**WEST SUSSEX COUNTY COUNCIL
PLANNING SERVICES CONSULTATION**

SUBJECT: FG/198/16/PL

Demolition of existing house with erection of 2 storey building comprising of 8No. residential 2 bedroom flats & associated external works.

1, Sea Drive, Ferring, BN12 5HD

BASEMENT FLOOR PLAN

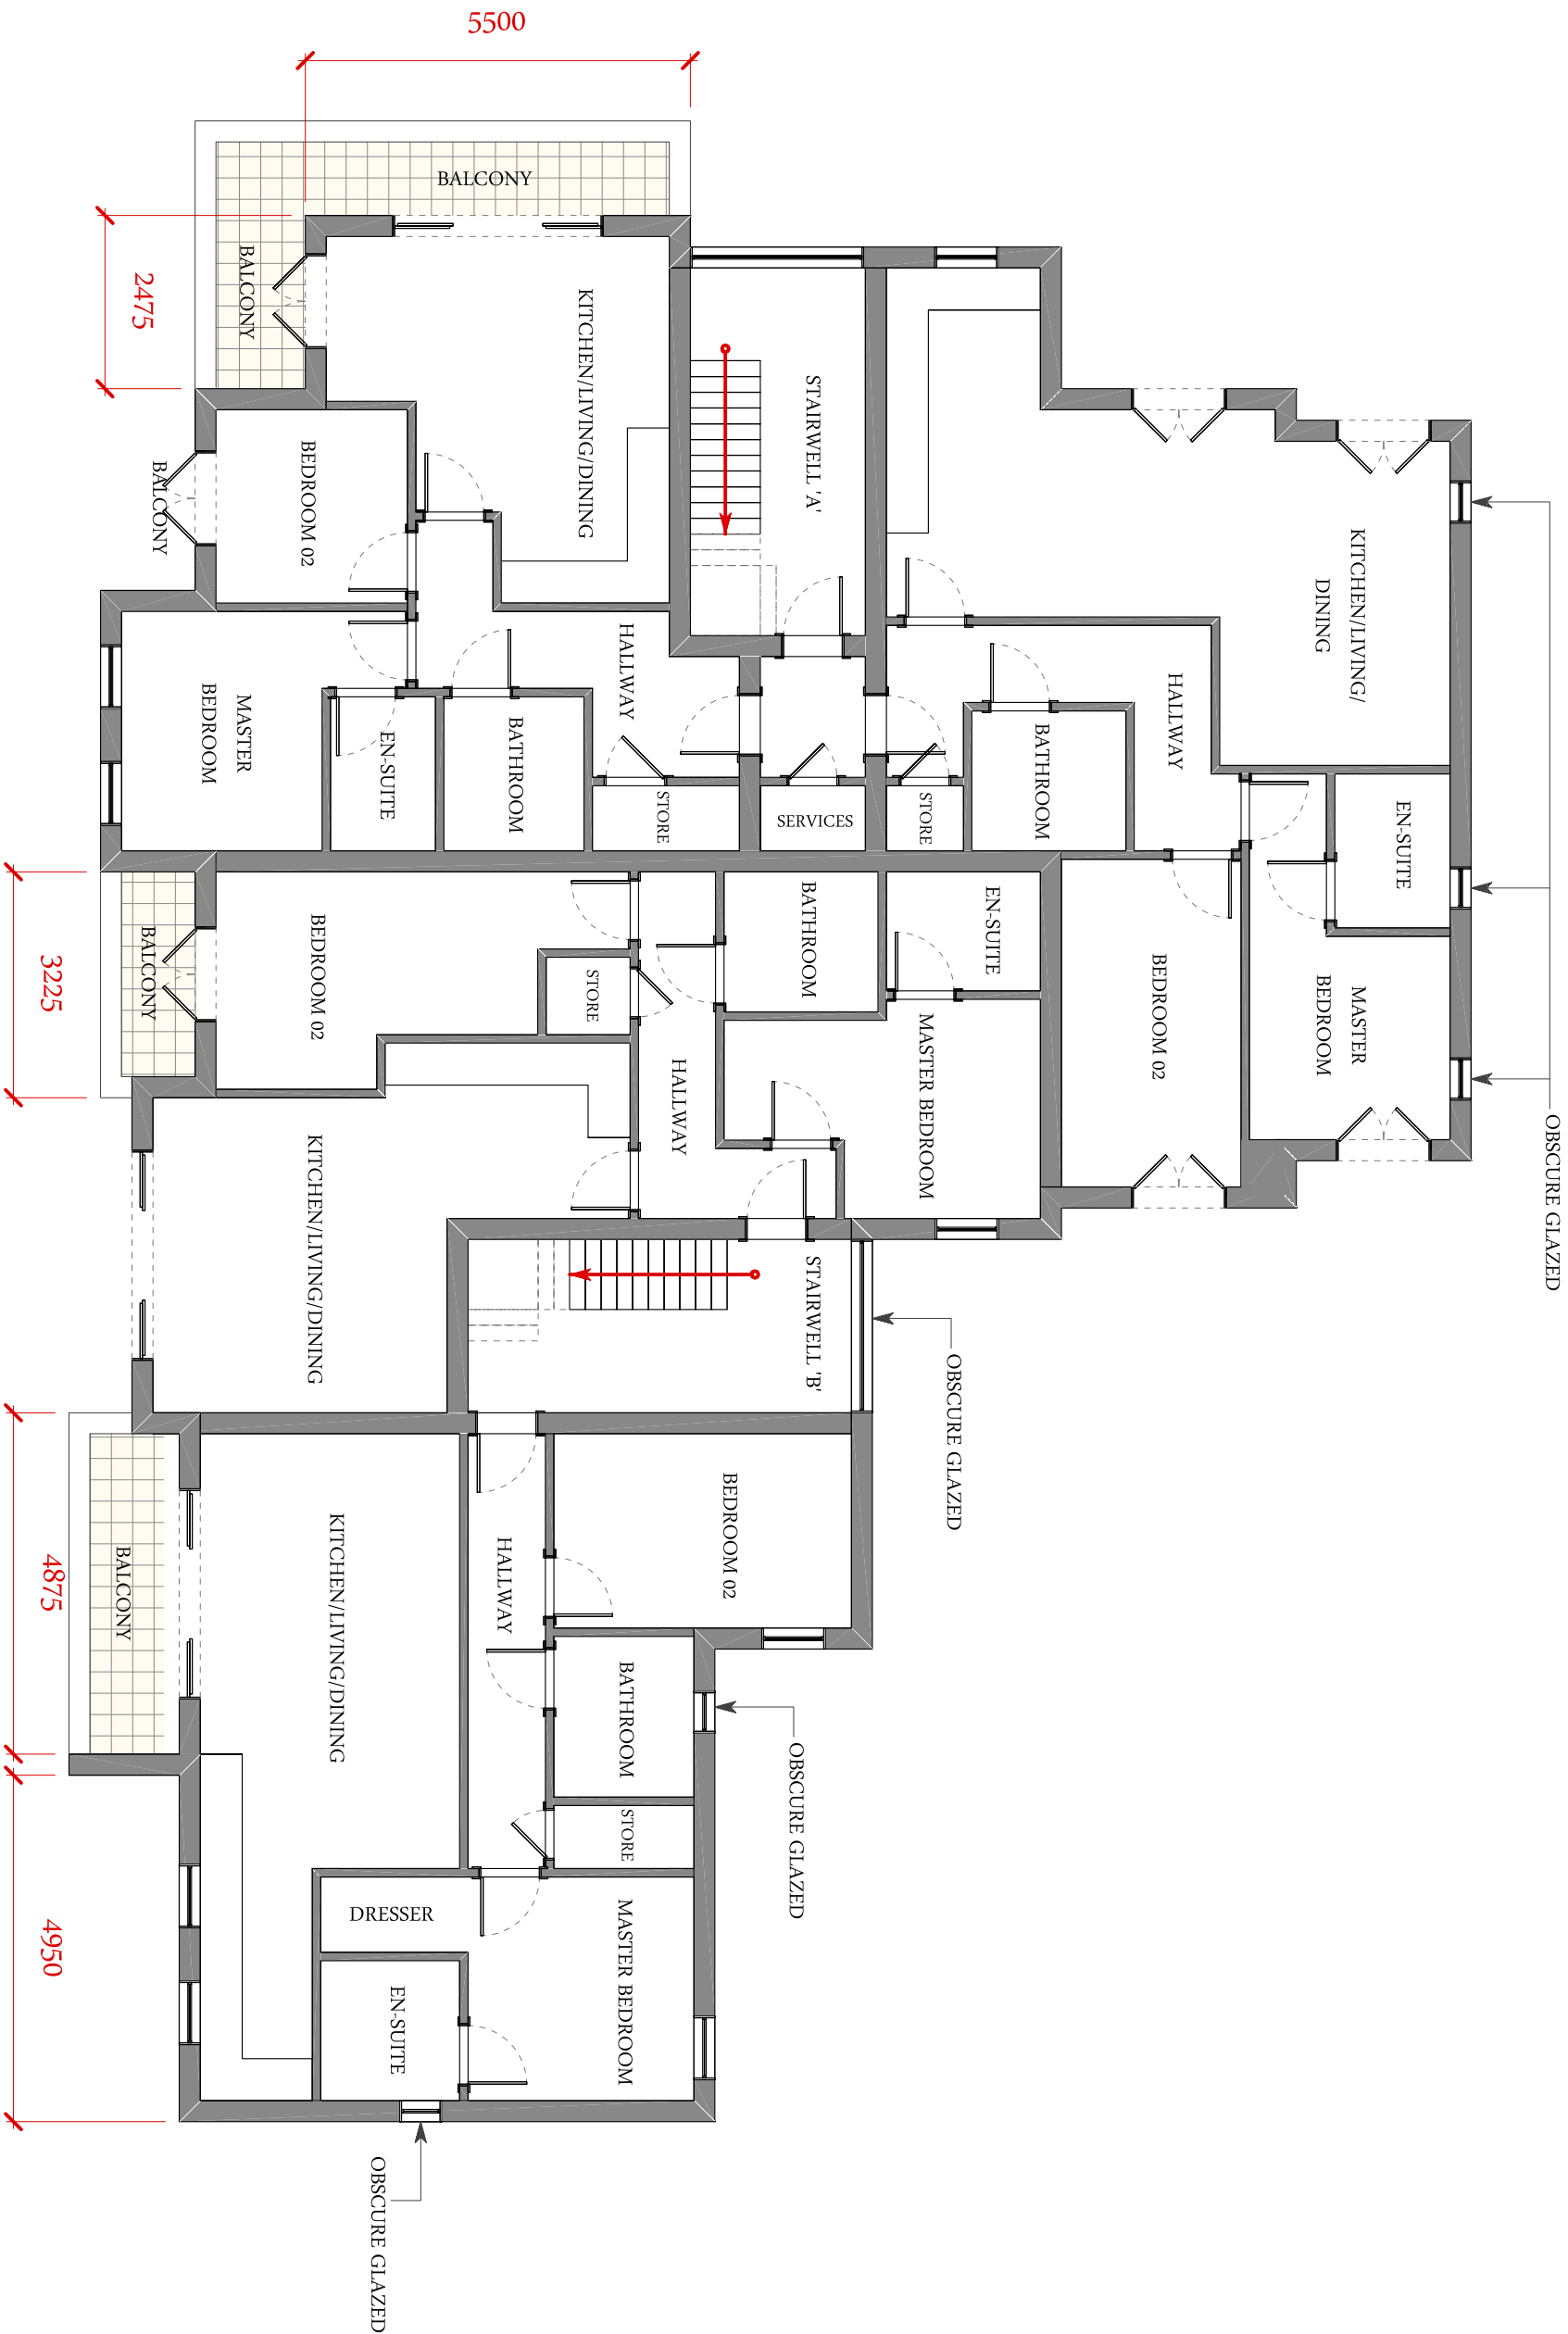
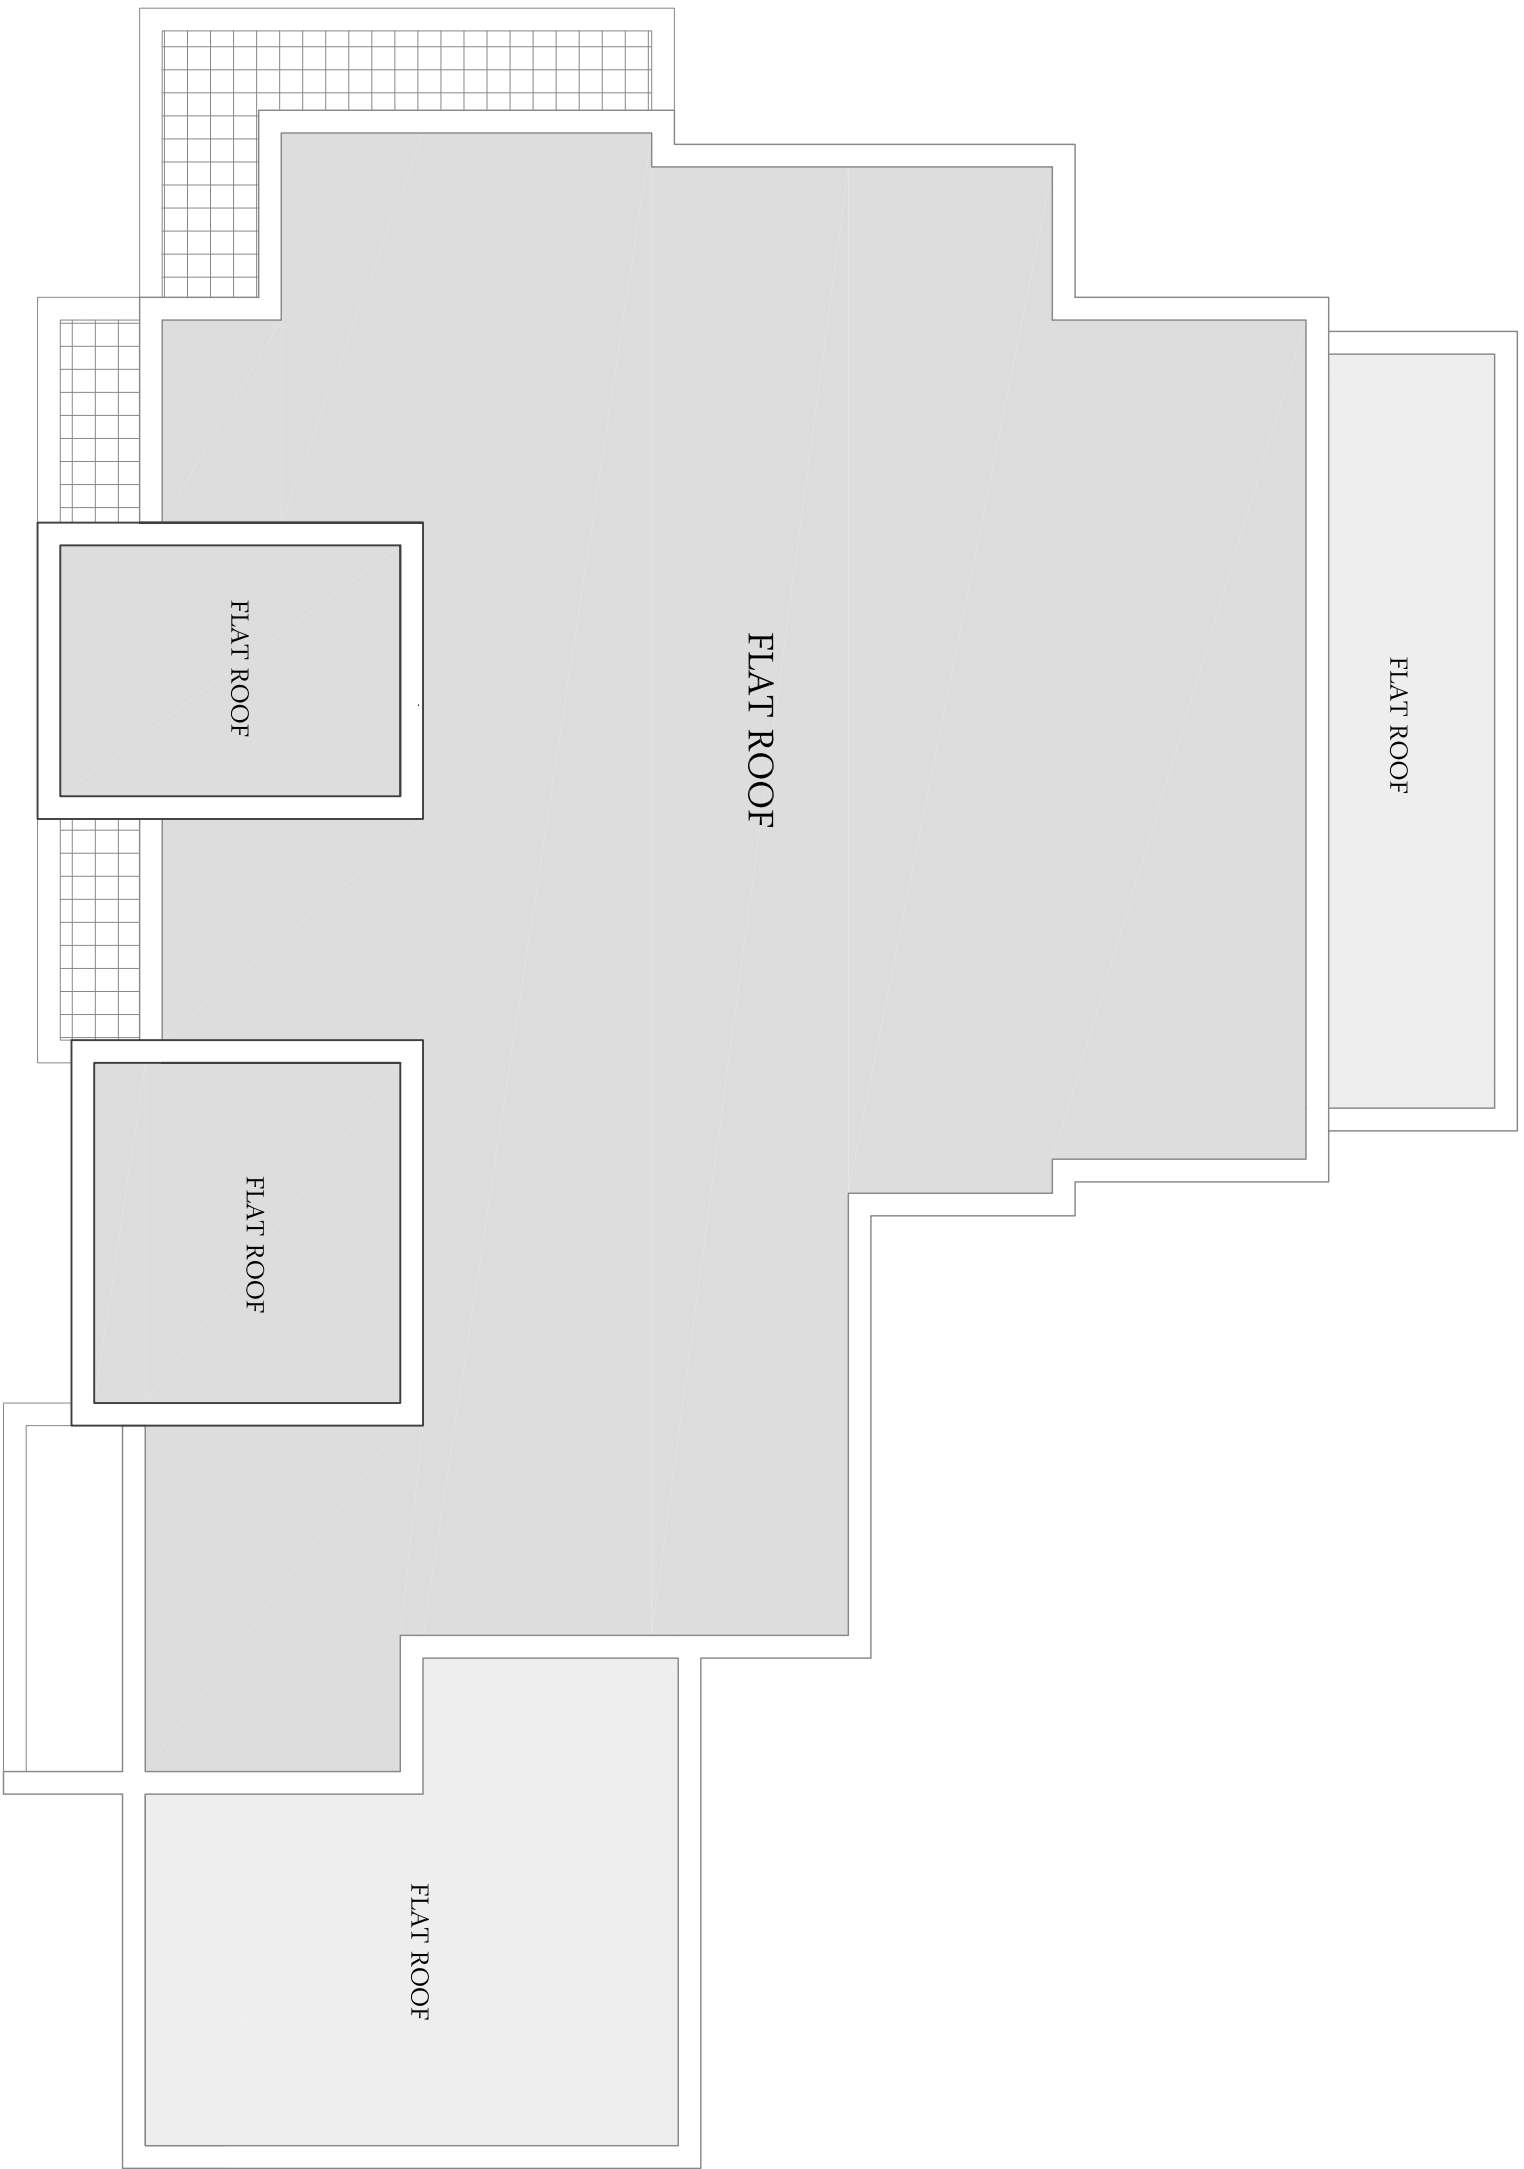
Substitute plan PL004 Rev L proposes to increase the parking provision by 3 spaces, increasing total capacity of the car park to 10 spaces. The Applicant has subsequently submitted plan PL007 Rev A which provides a vehicular tracking assessment of the revised layout.

The landing area at the bottom of the ramp has been extended to accommodate a parking space. This will discourage parking outside of the marked bays at this location. In turn, this will protect the space required to undertake a turning manoeuvre, should a vehicle enter the car park when all spaces are already occupied. The LHA have tracked this manoeuvre and confirm that an unimpeded 3-point turn can be undertaken.

TITLE: BASEMENT PARKING VEHICLE
SWEEP PATH DETAILS

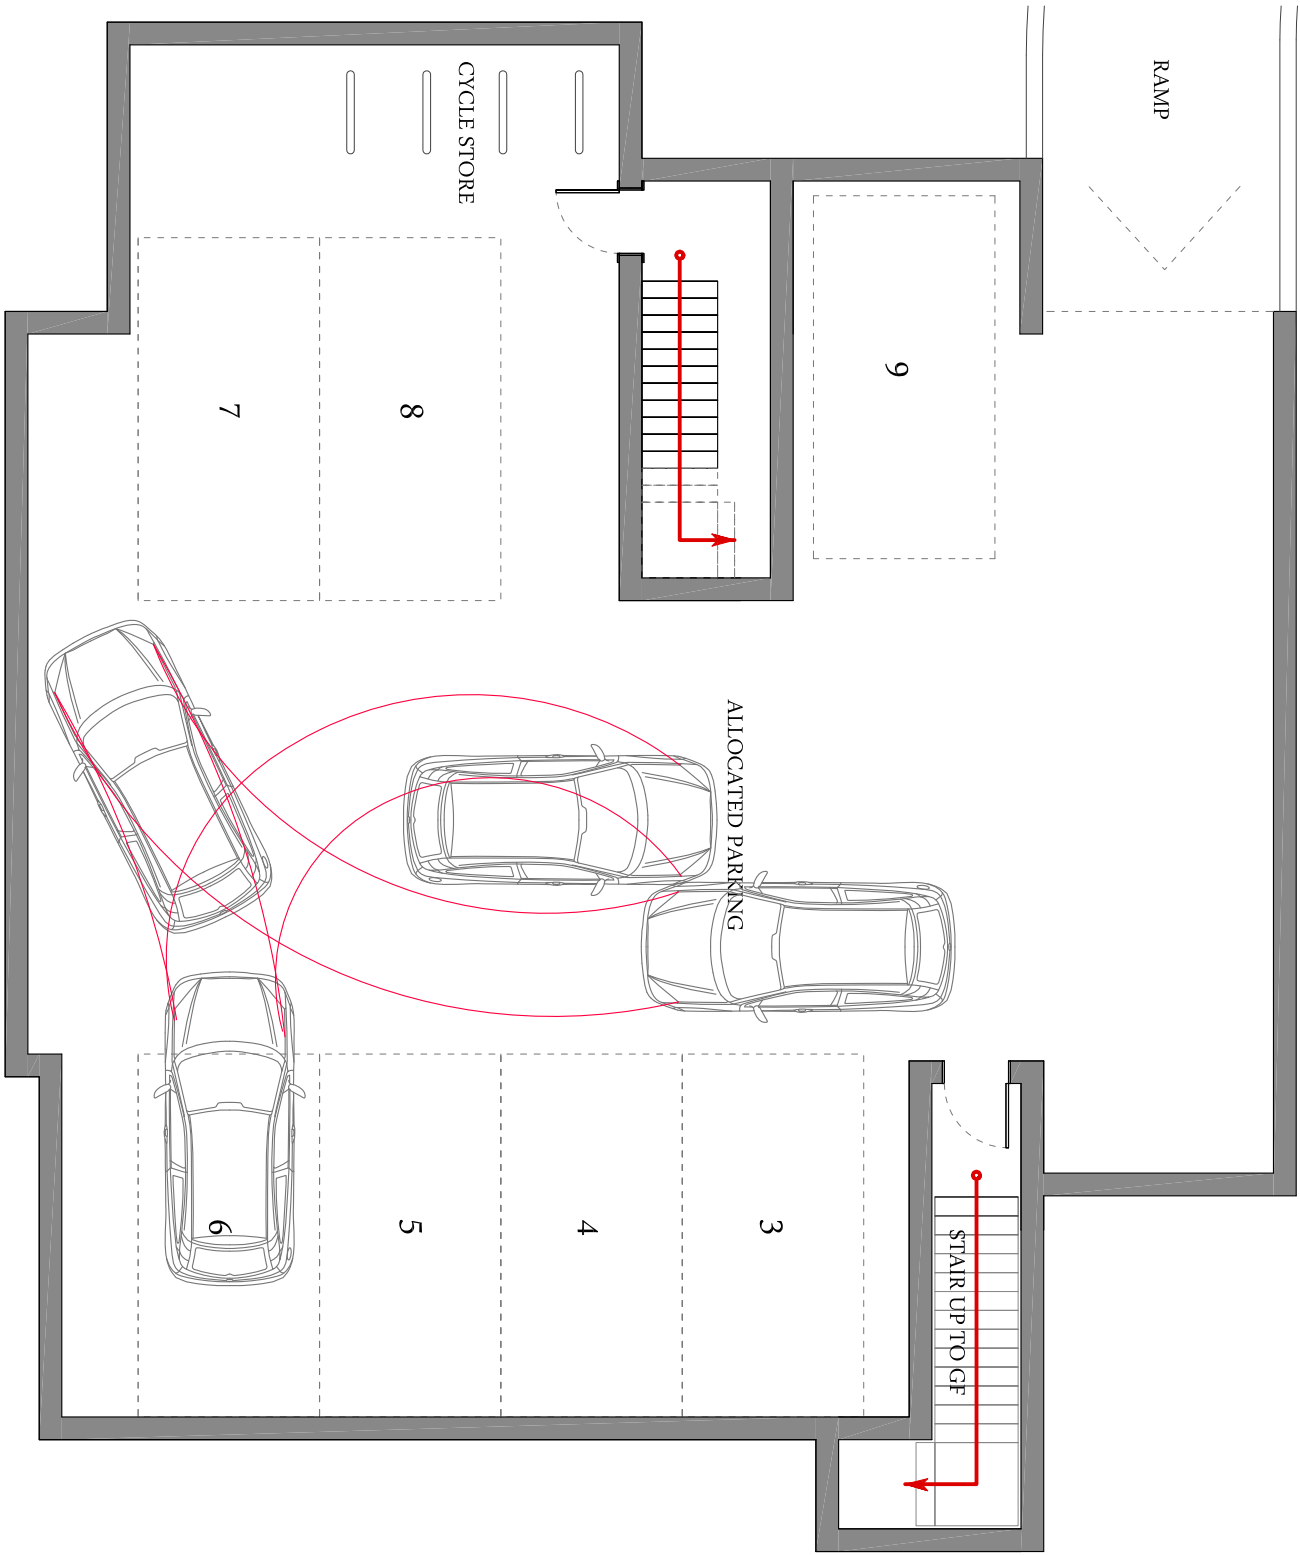
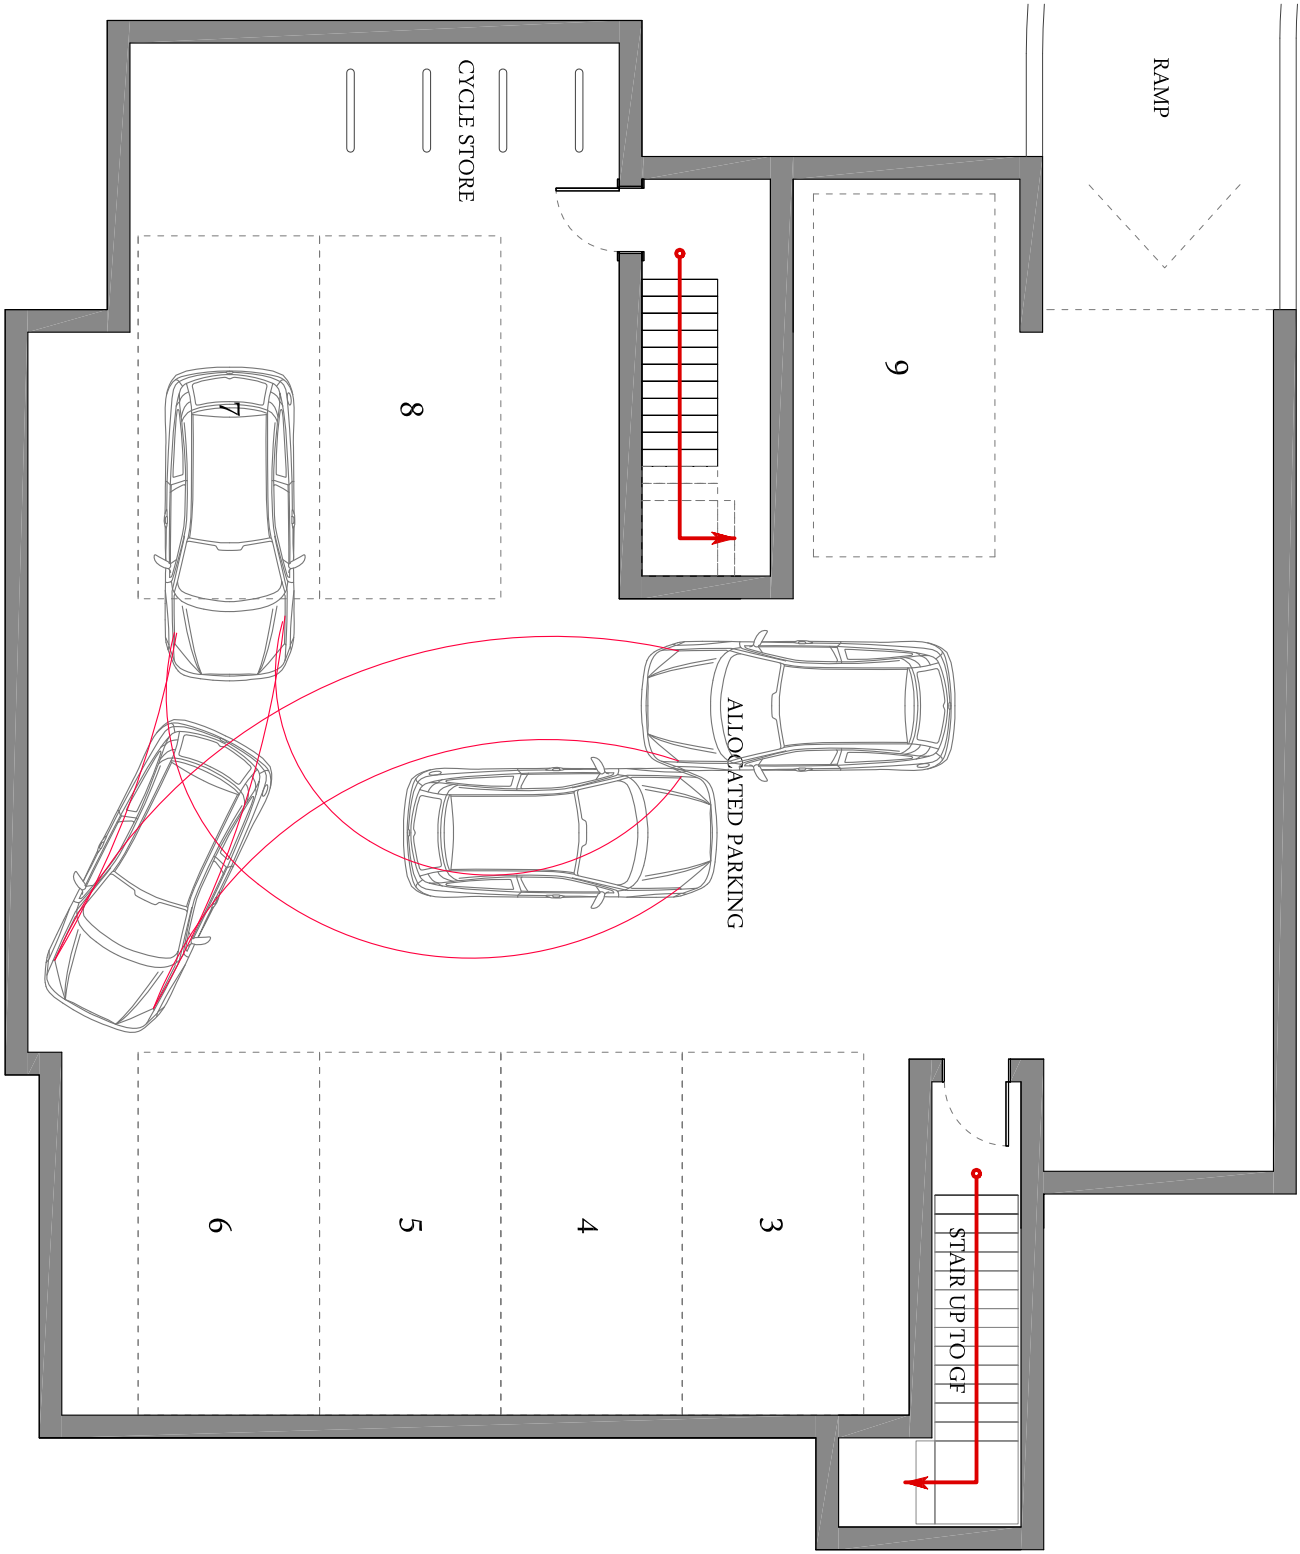
Both the parking bay and aisle width minimum dimensions have been maintained. It should be noted that these dimensions are also suitable for parking provision within structures (8.3.54, Manual for Streets 1). The tracking assessment submitted by the Applicant demonstrates that the reversing manoeuvre can be undertaken as part of a 3-point turn without coming into conflict with another vehicle or the structure itself.
